Re: University of Sheffield AMRC PND Modification

LPA Reference: Ribble Valley Borough Council JM/3/2019/1061

South Ribble Borough Council 07/2019/12212/LDO

I write with regards proposed amendments sought to be made to the above mentioned approvals of development associated with The University of Sheffield's Prior Notification of Development (PND) submissions for the Advanced Manufacturing Research Centre (AMRC) North West (NW) facility at the Lancashire Advanced Engineering and Manufacturing Enterprise Zone (Samlesbury).

Drawing No.
832-CPA-ZZ-ZZ-DR-A-2200

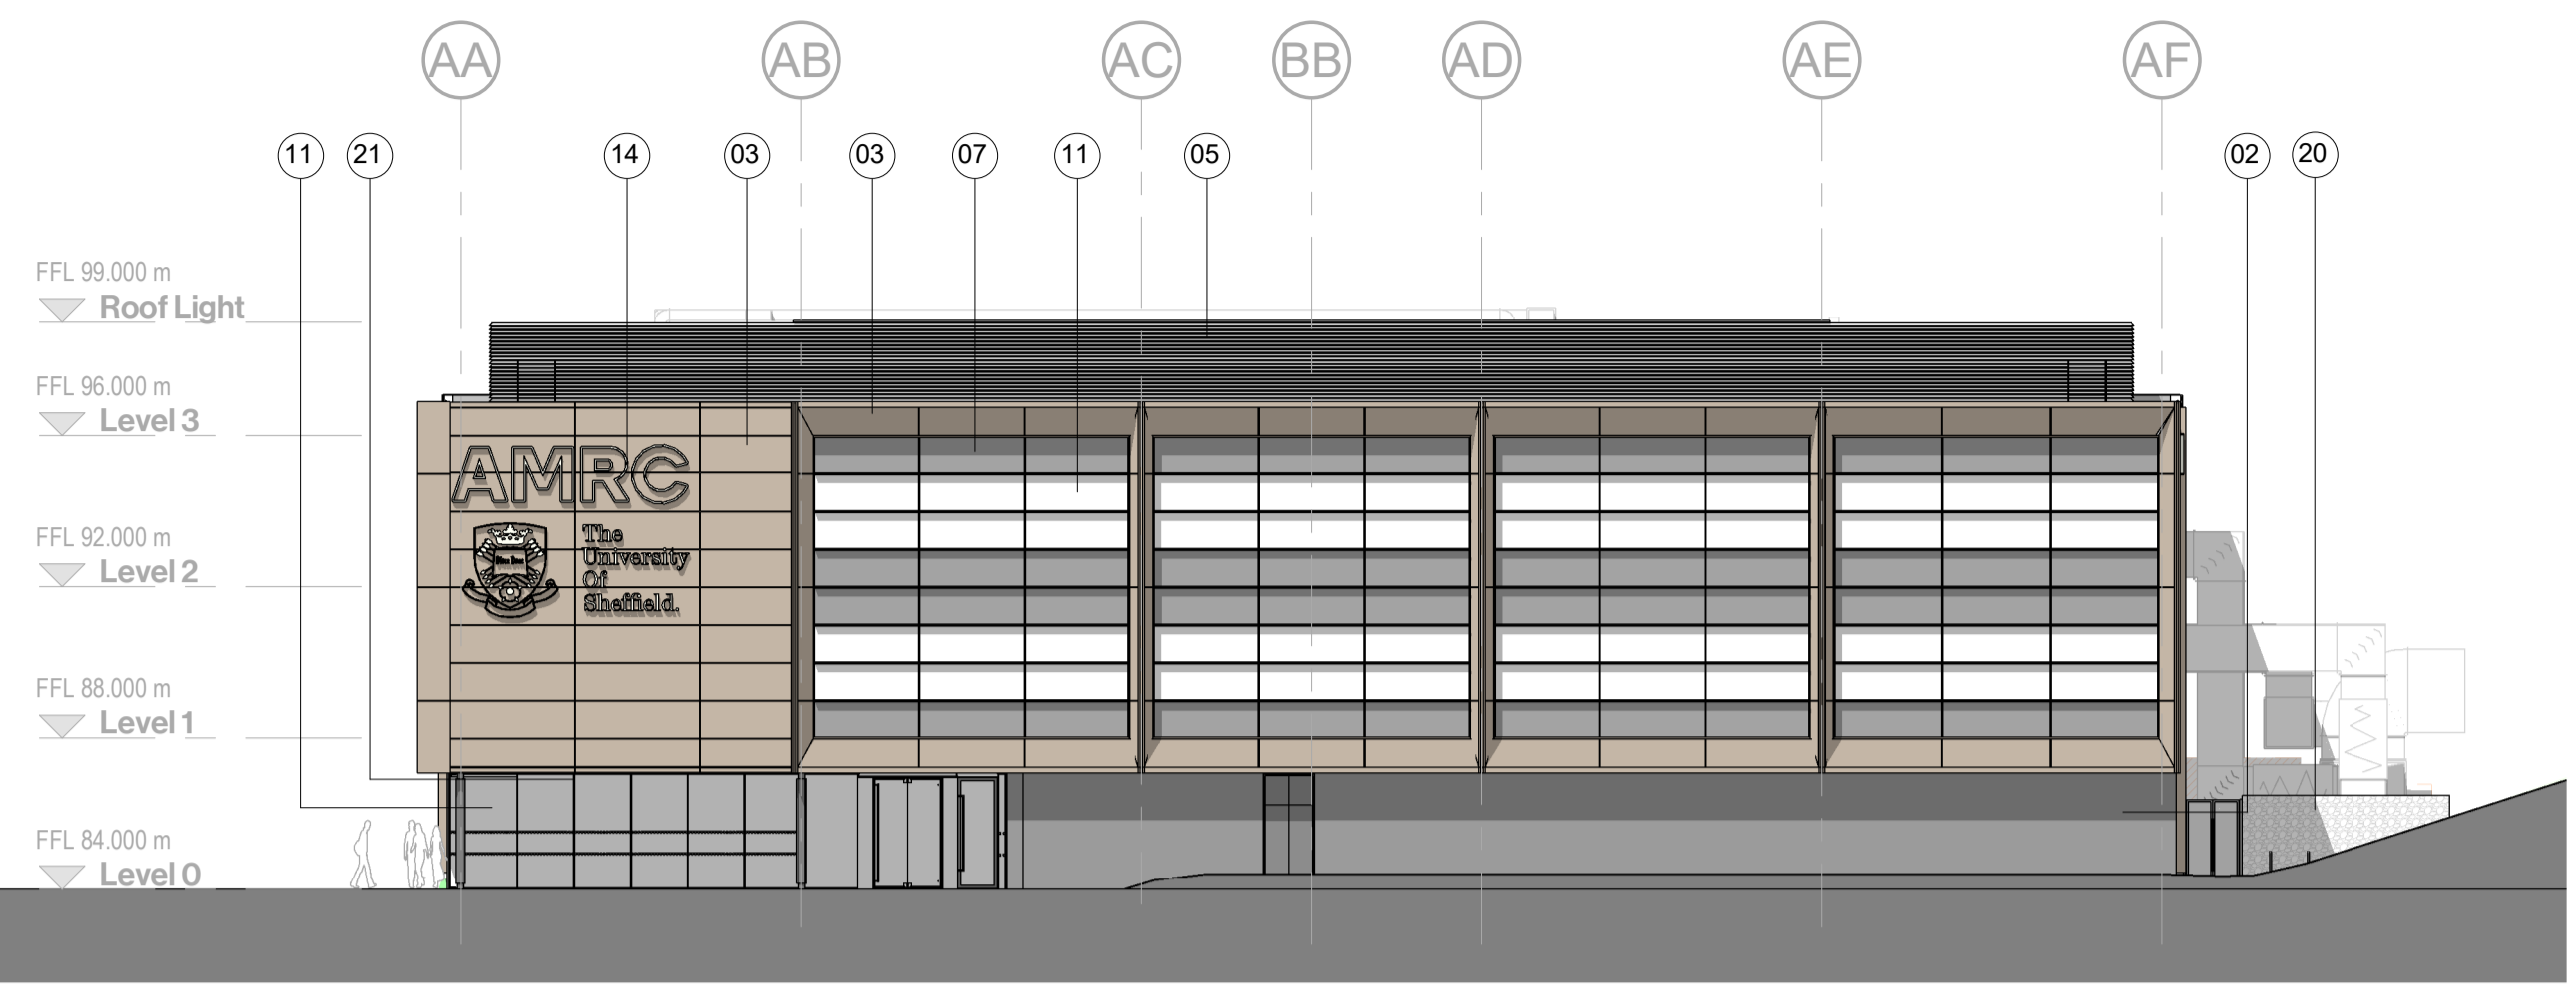
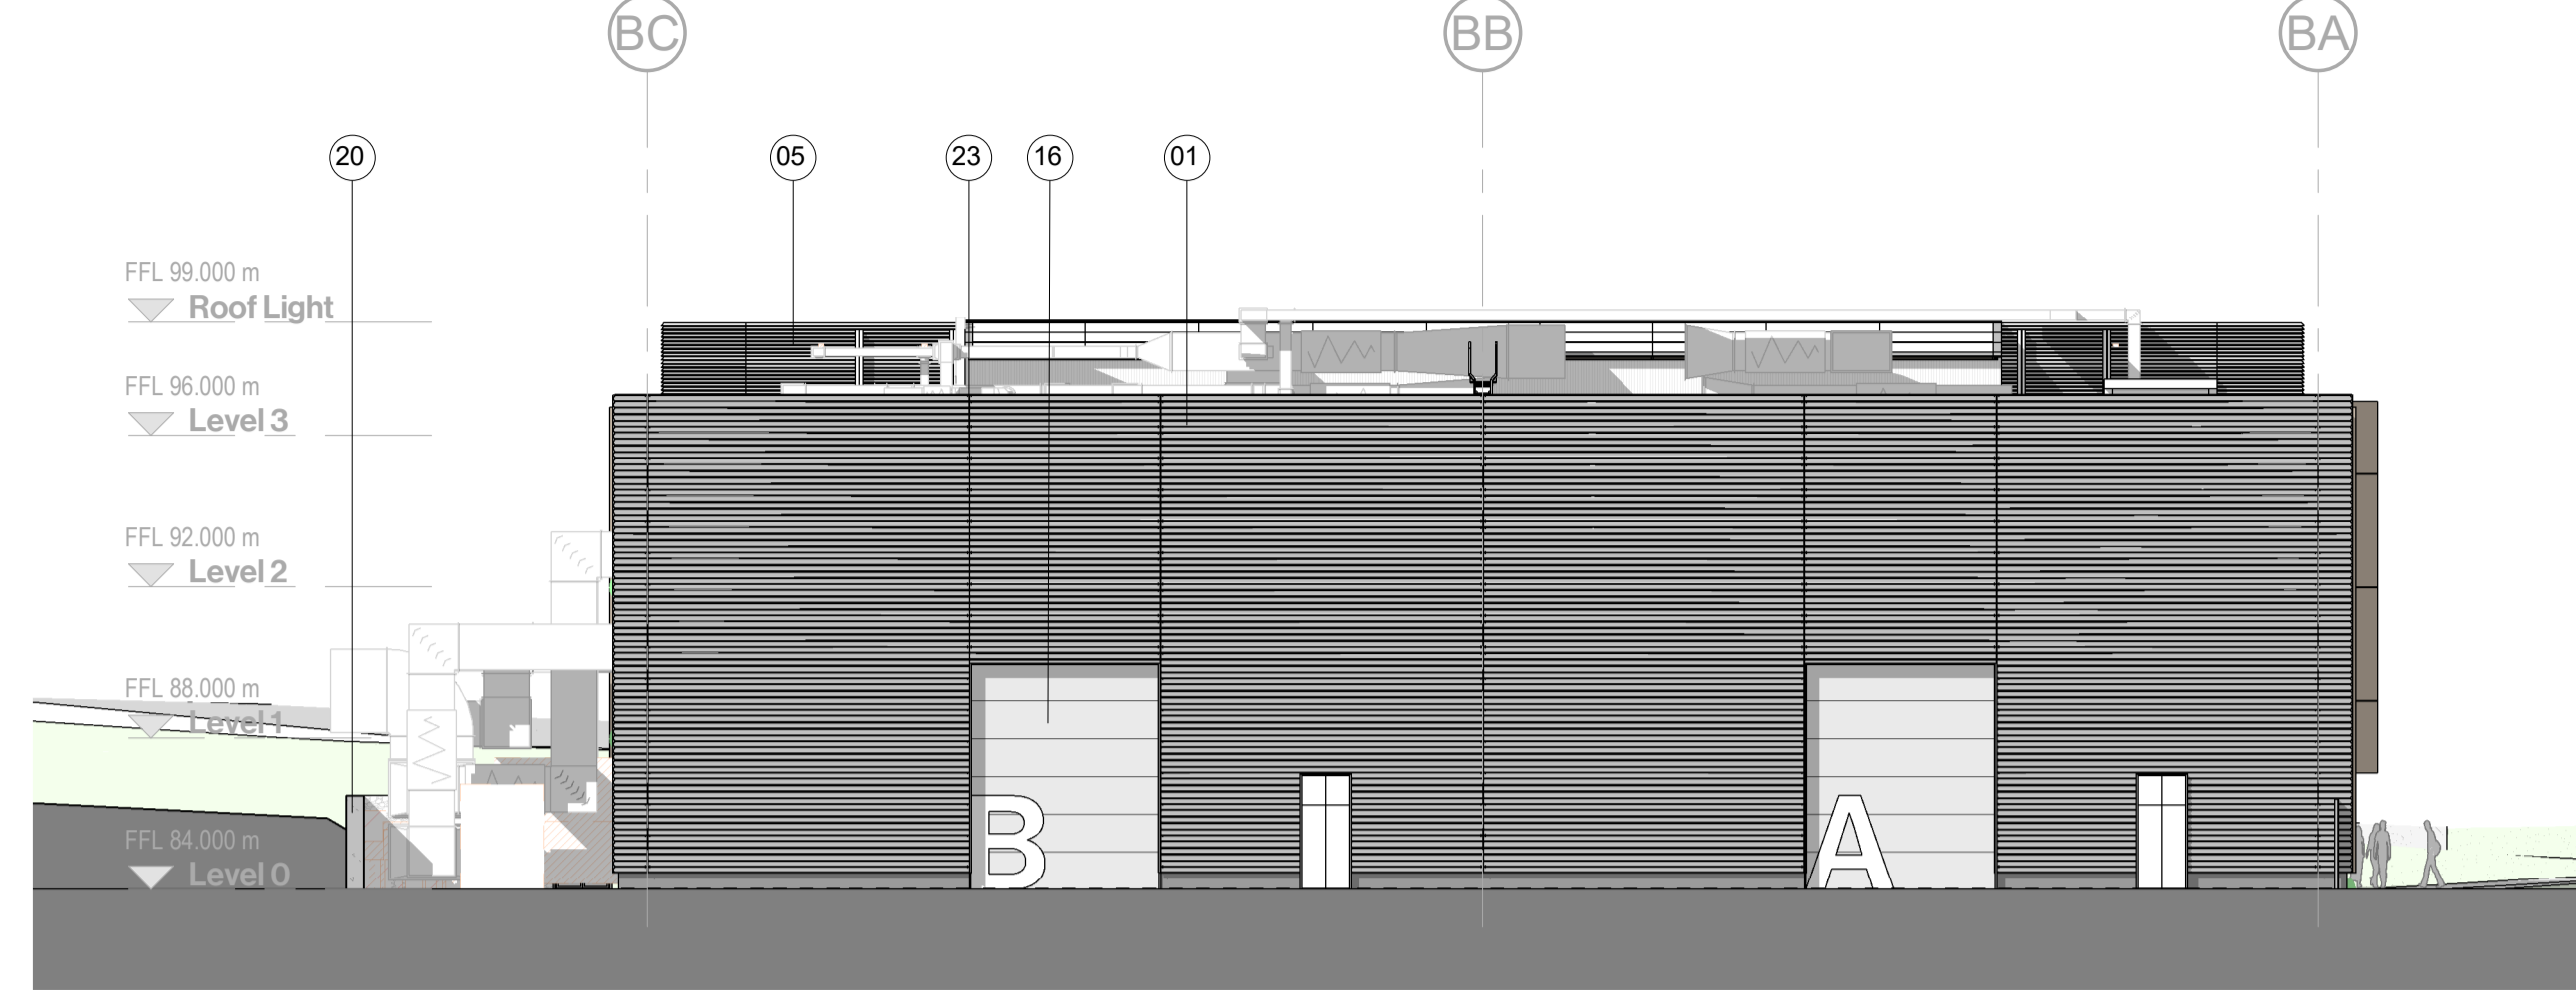
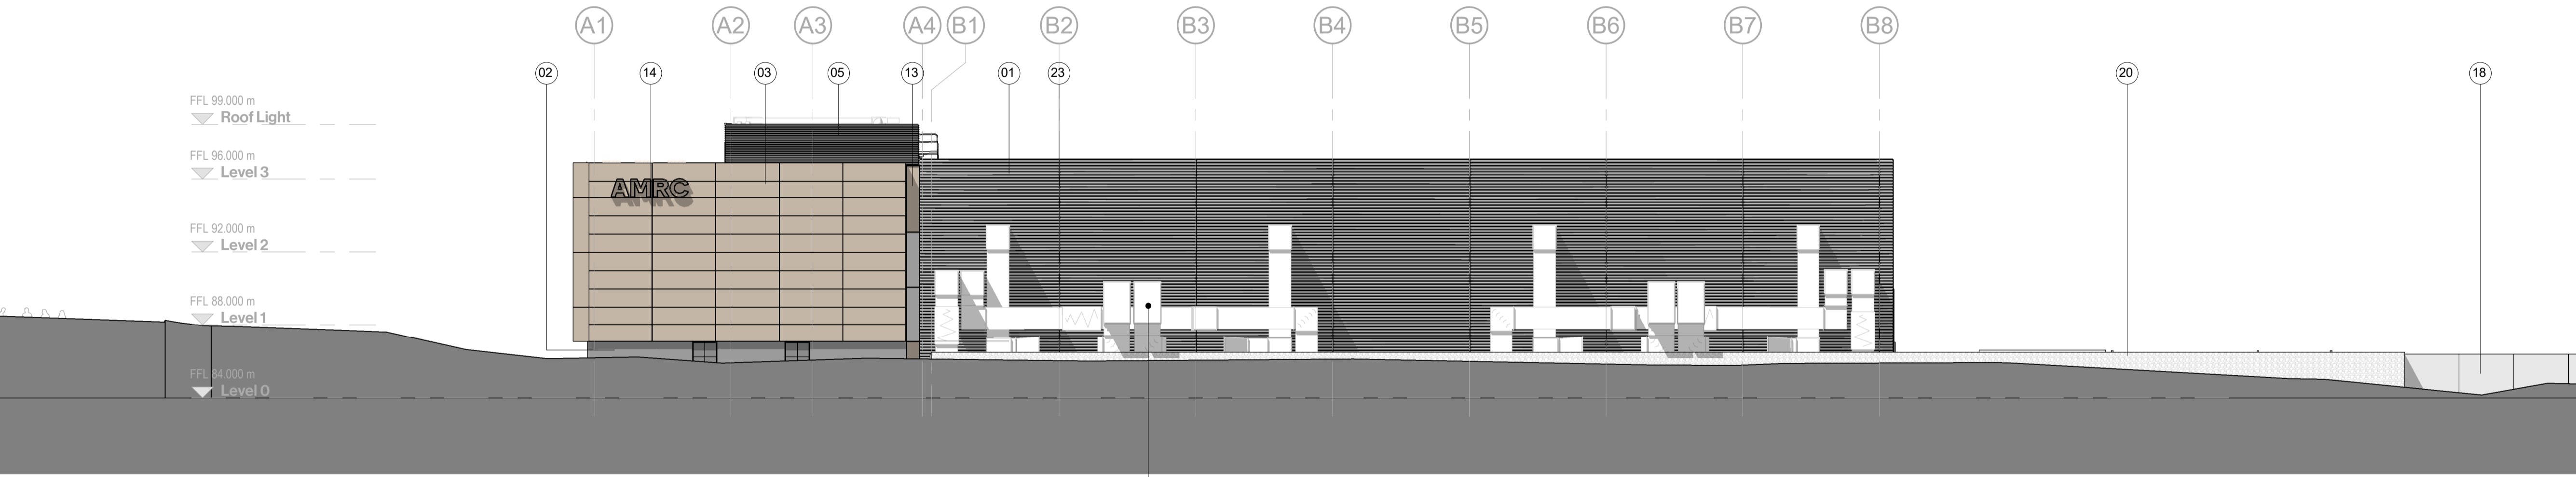
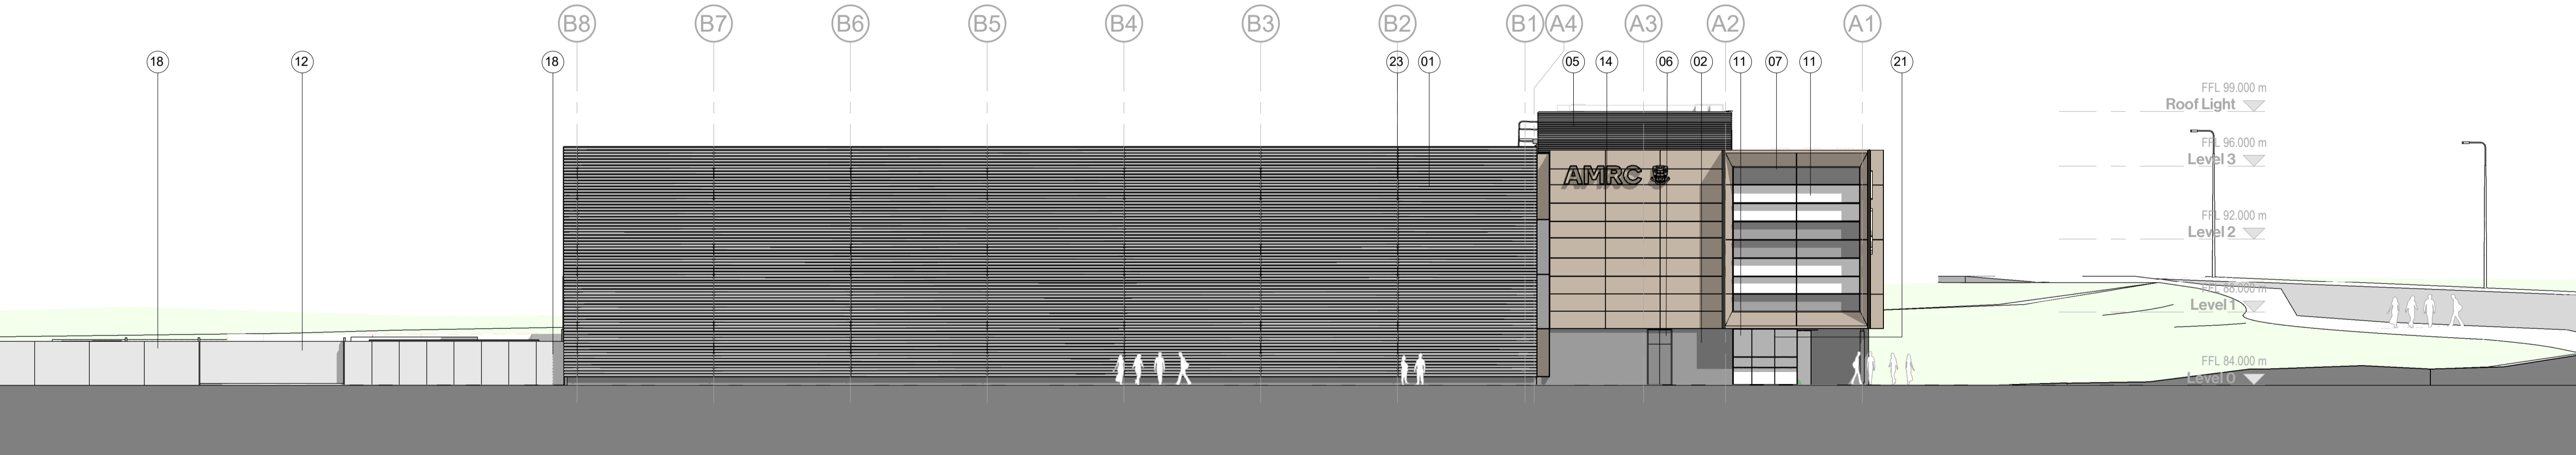
- The separation between the projecting bays have been omitted.
- The bay projections are reduced to 750mm from 1500mm.
- Slot windows and rooflights have been removed from the workshop area to create controlled environment.
- Vertical fins are now used to break down the mass of the workshop elevations.
- There is a reduction in tree planting with the focus on landscaping screening the car park and removing trees from swales.
- Hardstanding has been reduced and the service yard corner has been replaced with wildflower planting.

The 3D visuals and elevation treatments and demonstrate that the key architectural features, such as the south framing are retained and the revised scheme aligns with the original architectural aspirations for this gateway site. The original materials have been retained and rationalised, although it has now been established that that the workshop area is required to be a 'black box' controlled space which has required design amendments.
